# **Application by Highways England for an Order Granting Development Consent for A57 Link Roads**

## **The Examining Authority's third written questions and requests for information**

### **High Peak Borough Council's Response**

Drawing Number	HE551473 - BBA - EGN - A57_AL_SCHEME - DR - LE - 060414
Location	Location
Scale	1:5,000
Original Size	A3
Rev	P01

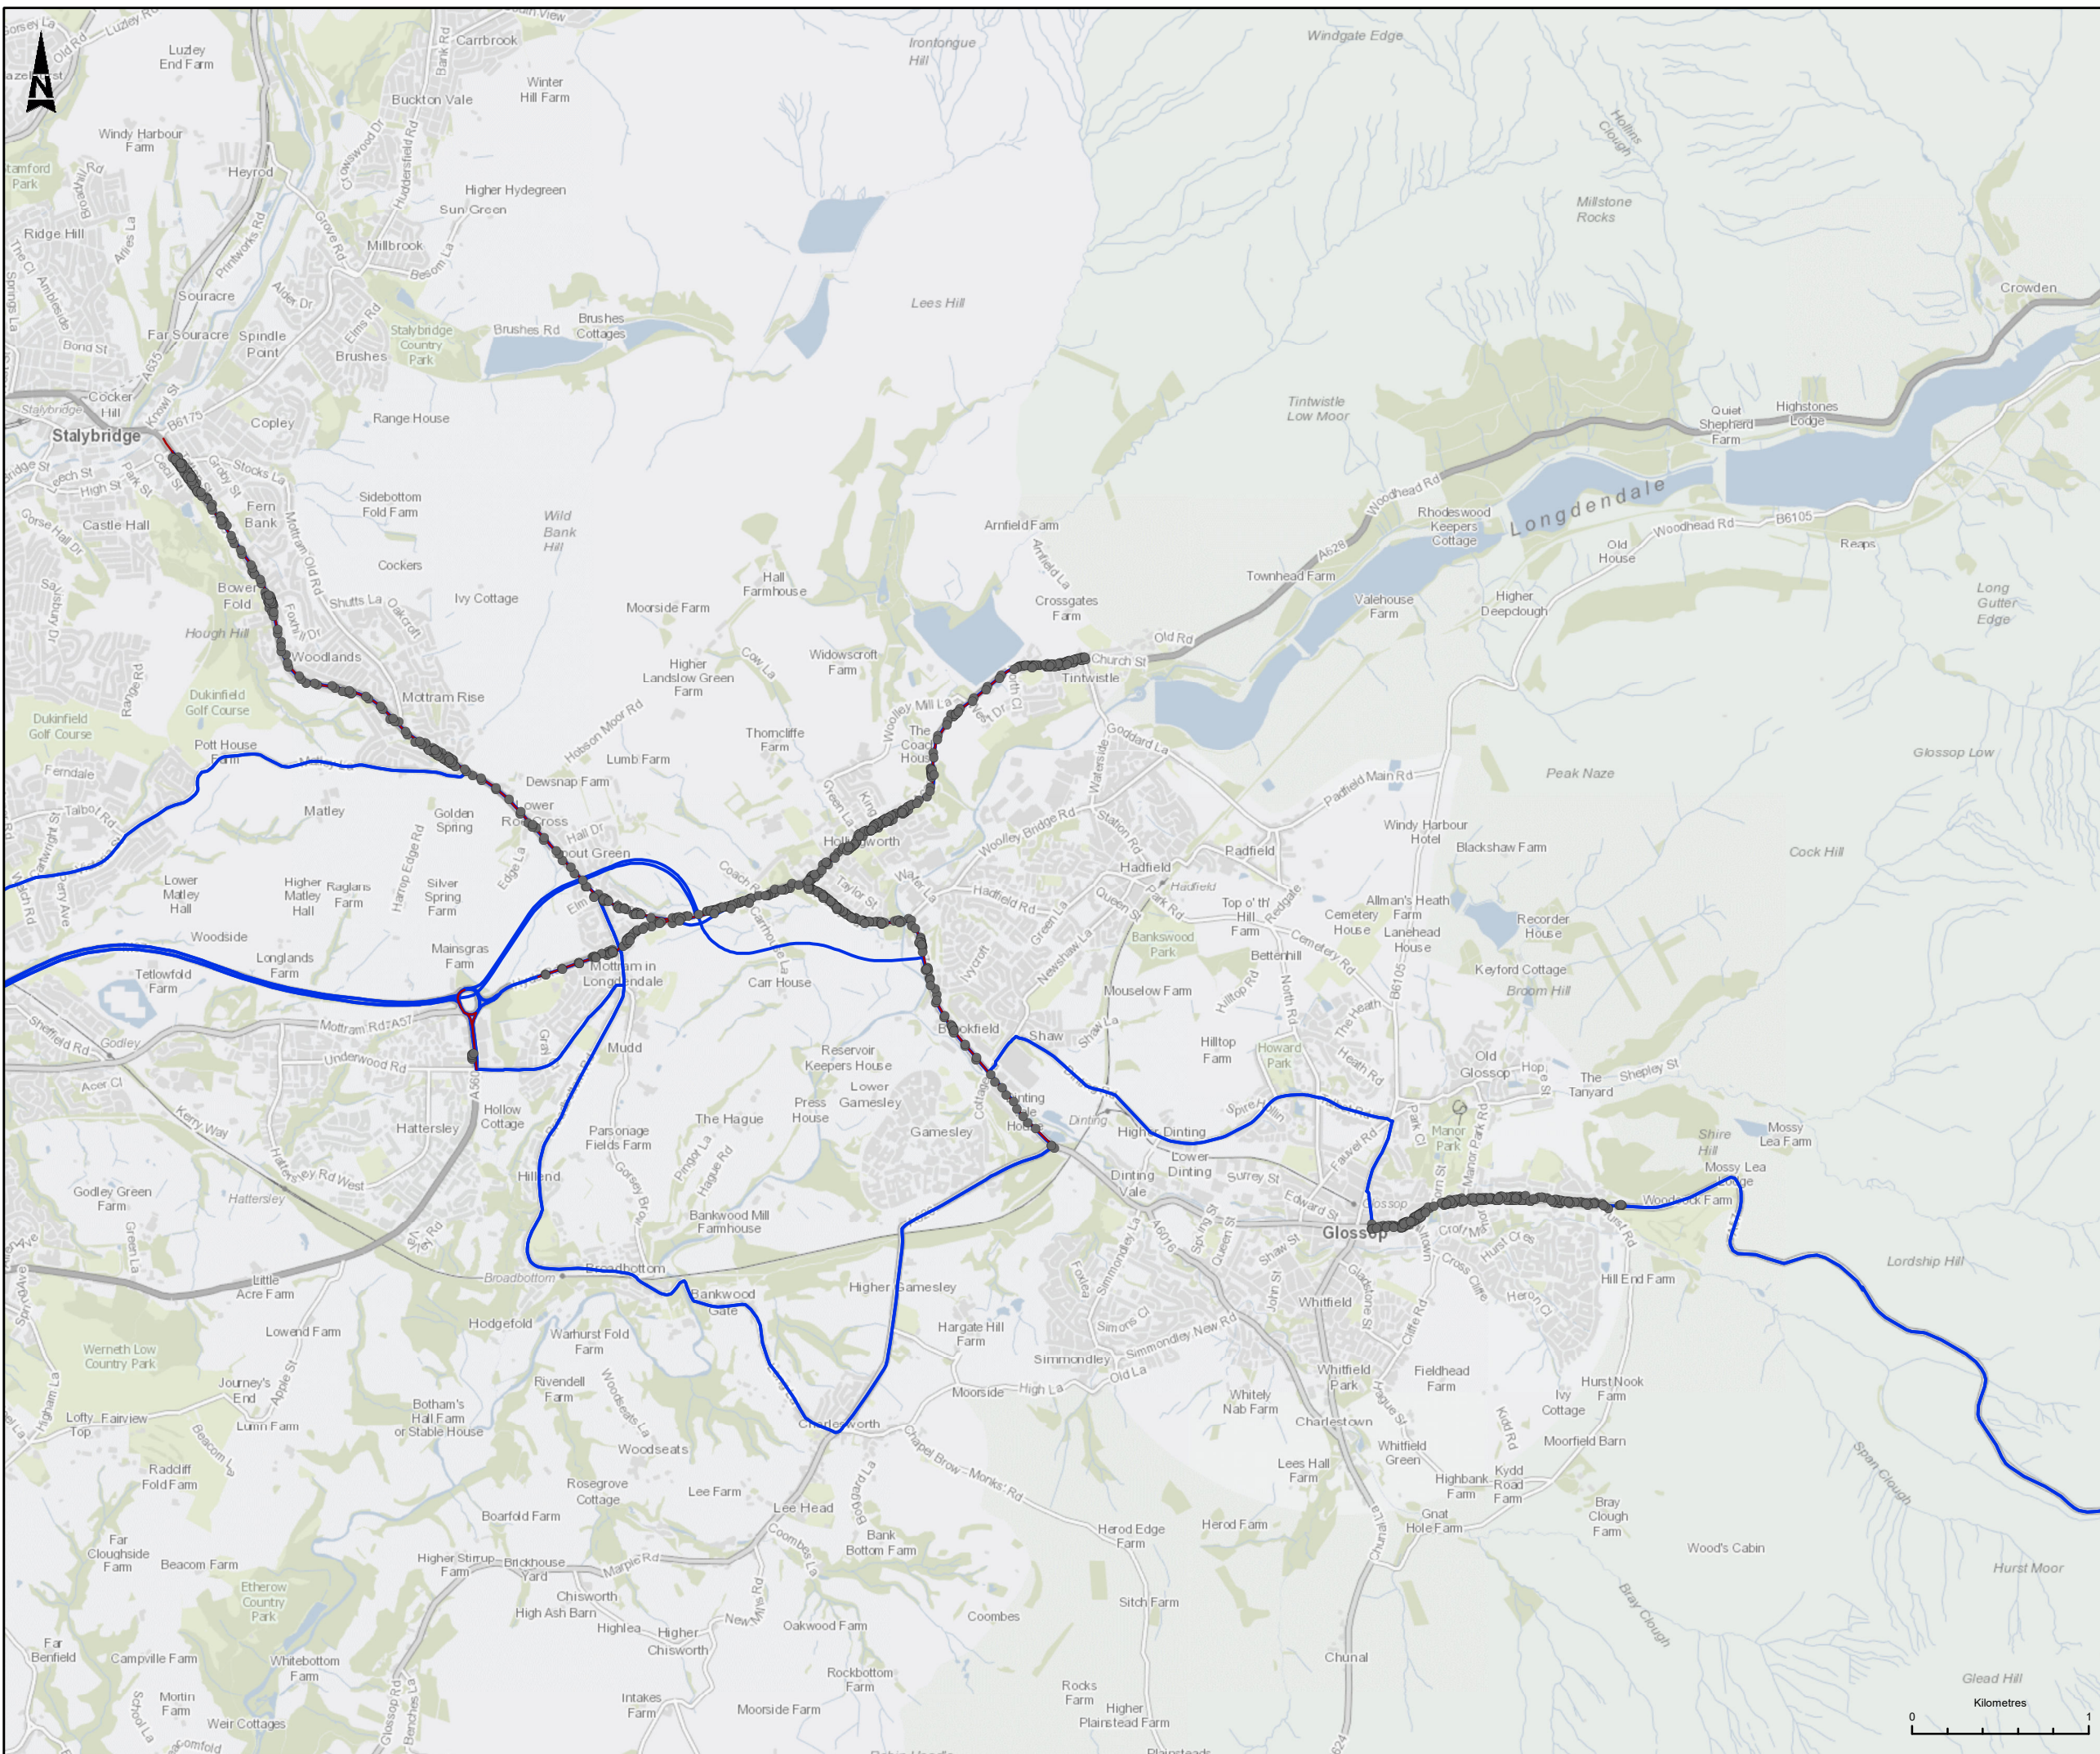
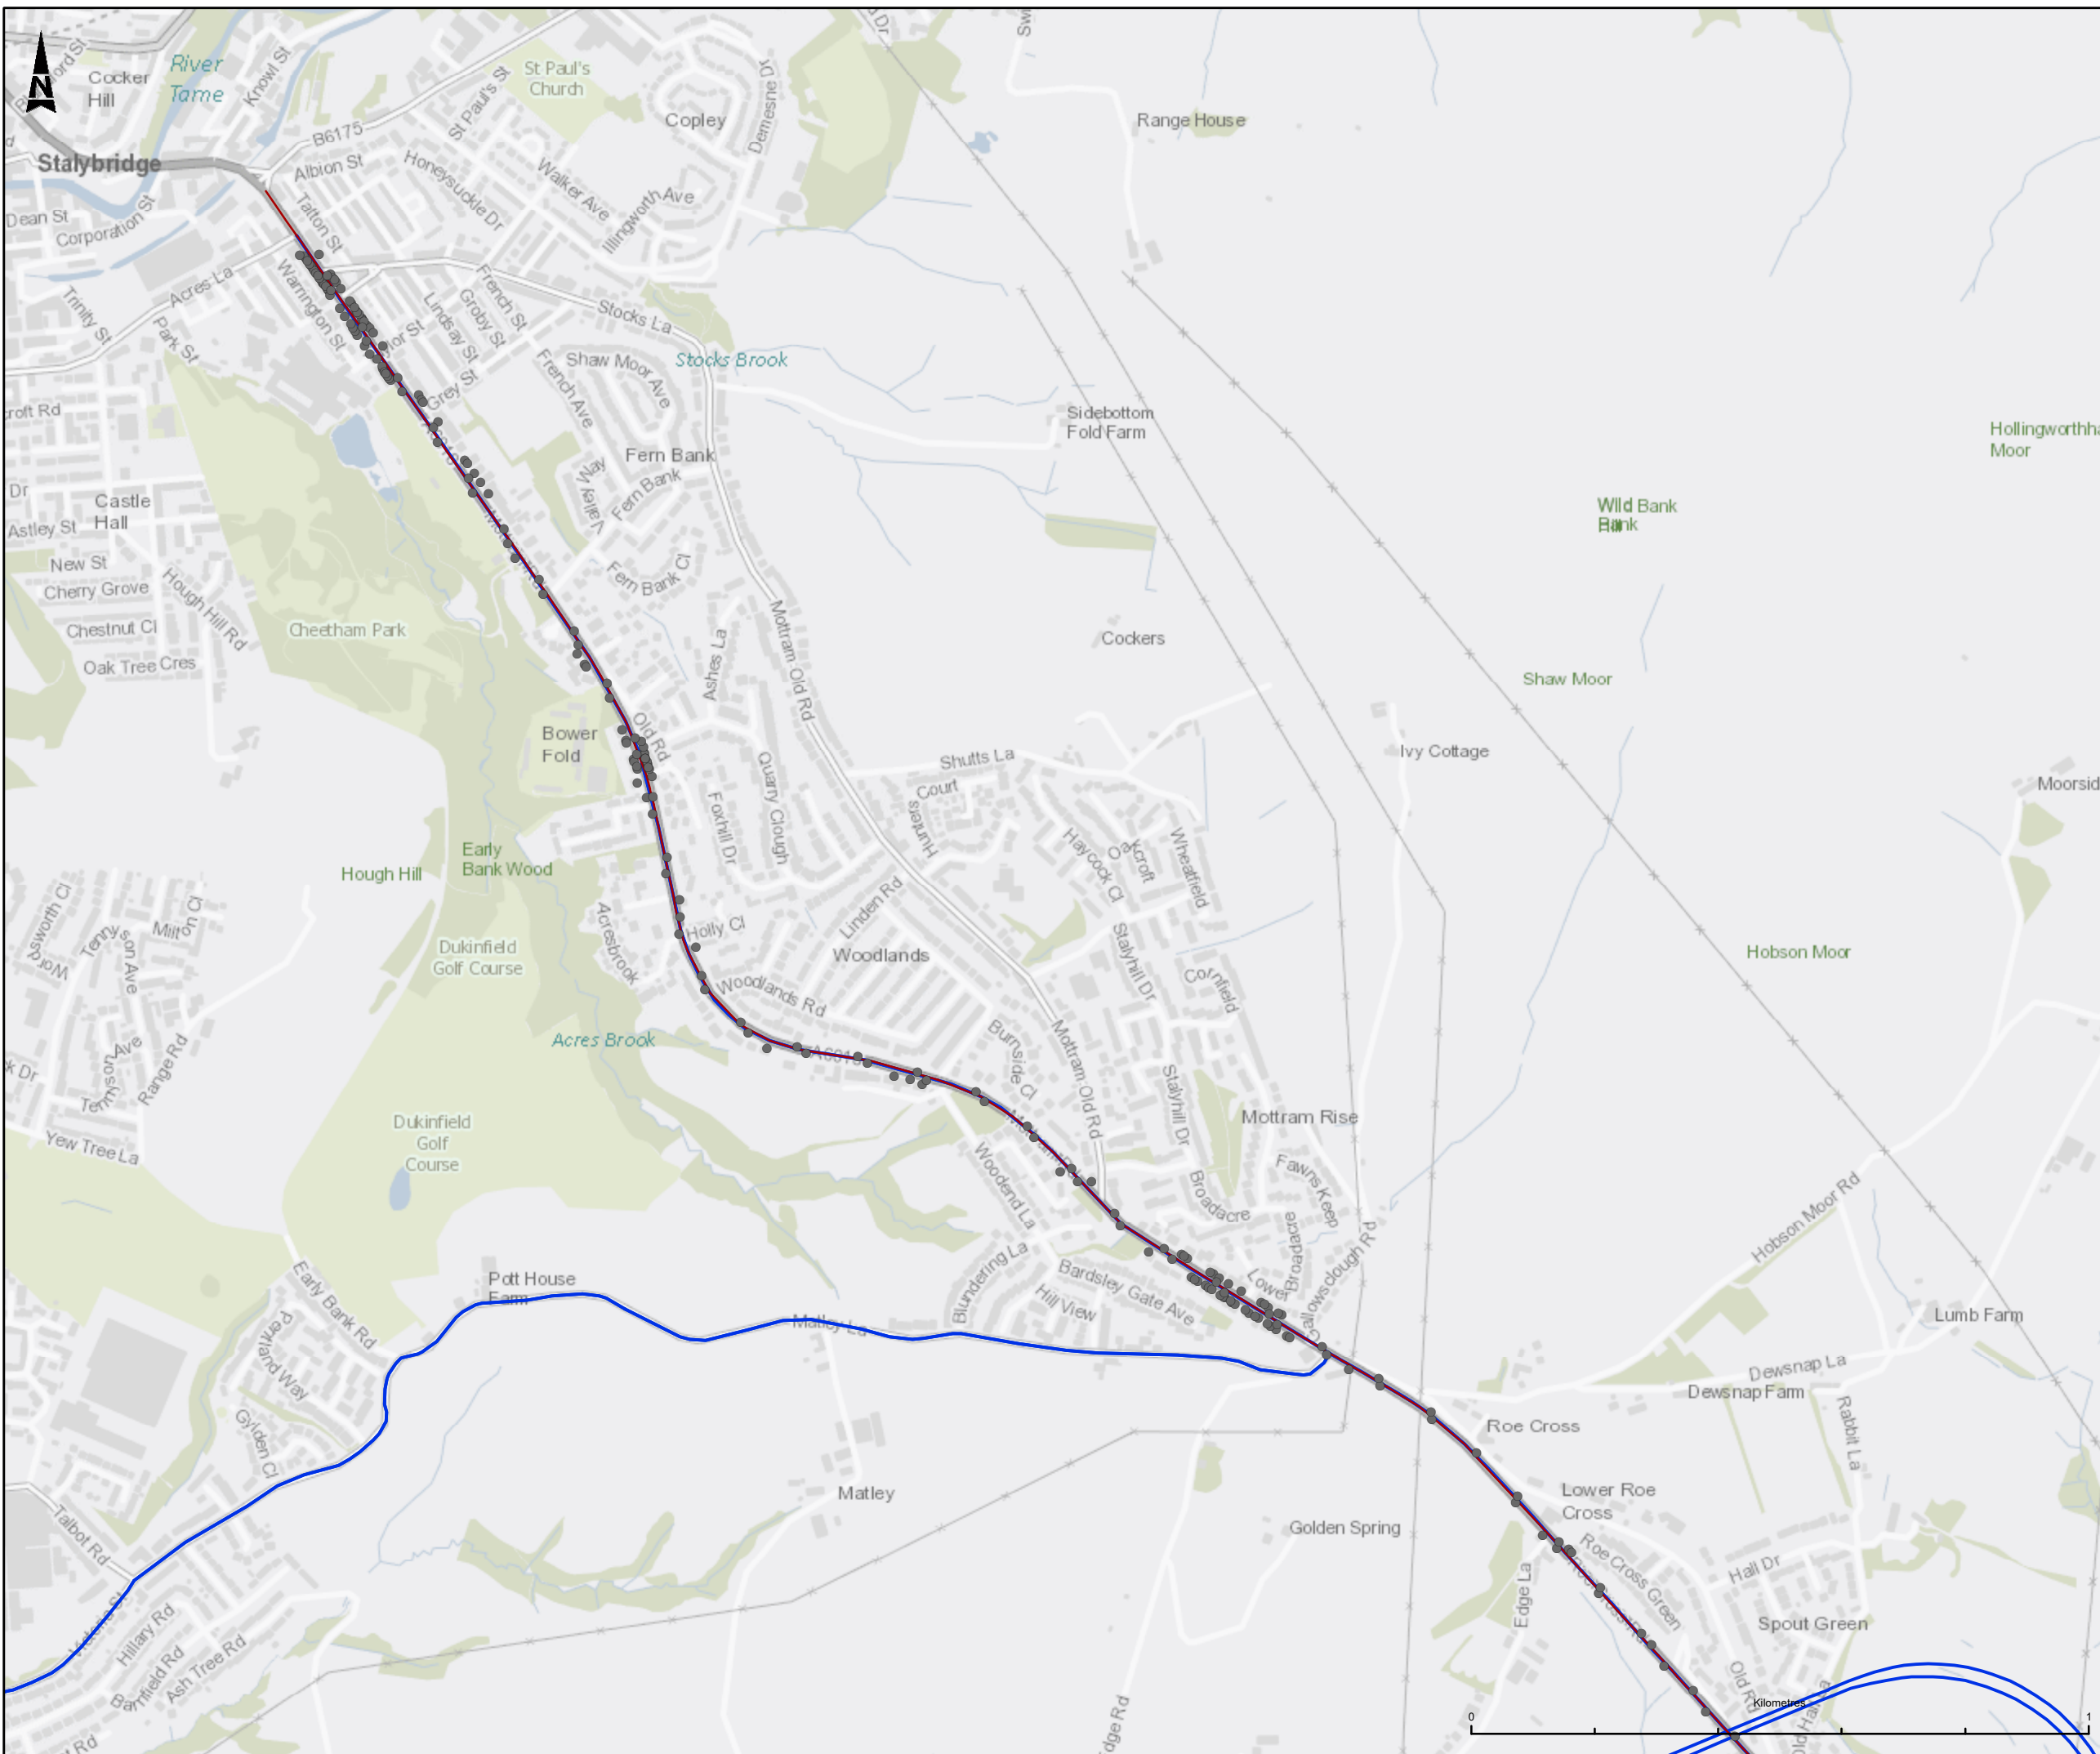
Identification of the receptors (figure 5.4) used in the compliance risk assessment (using LAQM “conservative” forecast”) indicated that “large” change at some of the receptors along Brookfield.

However, it also highlighted that some of these were human health receptors that had not been included as receptors in the (less conservative) primary human health AQ assessment (DMRB LA 105). Therefore, HPBC have requested that these receptors are also assessed in accordance with the DMRB LA 105 . Following further discussion and clarification (virtual meeting held 8th April 2022) it was agreed that a sensitivity test will be undertaken to identify the air quality impact at relevant qualifying feature receptors located adjacent to the A57 Brookfield under the DMRB LA 105 human health assessment methodology (to be submitted by National Highways at deadline 11 – ref. TR010034/EXAM/9.86)

Results from the updated air quality assessment updated DMRB LA 105 indicated a “Large increase” in NO<sub>2</sub> DS compared to DM in 2025, at locations along Wooley Bridge with 1 location exceeding the AQO (40ug/m<sup>3</sup>) as a result of the scheme.
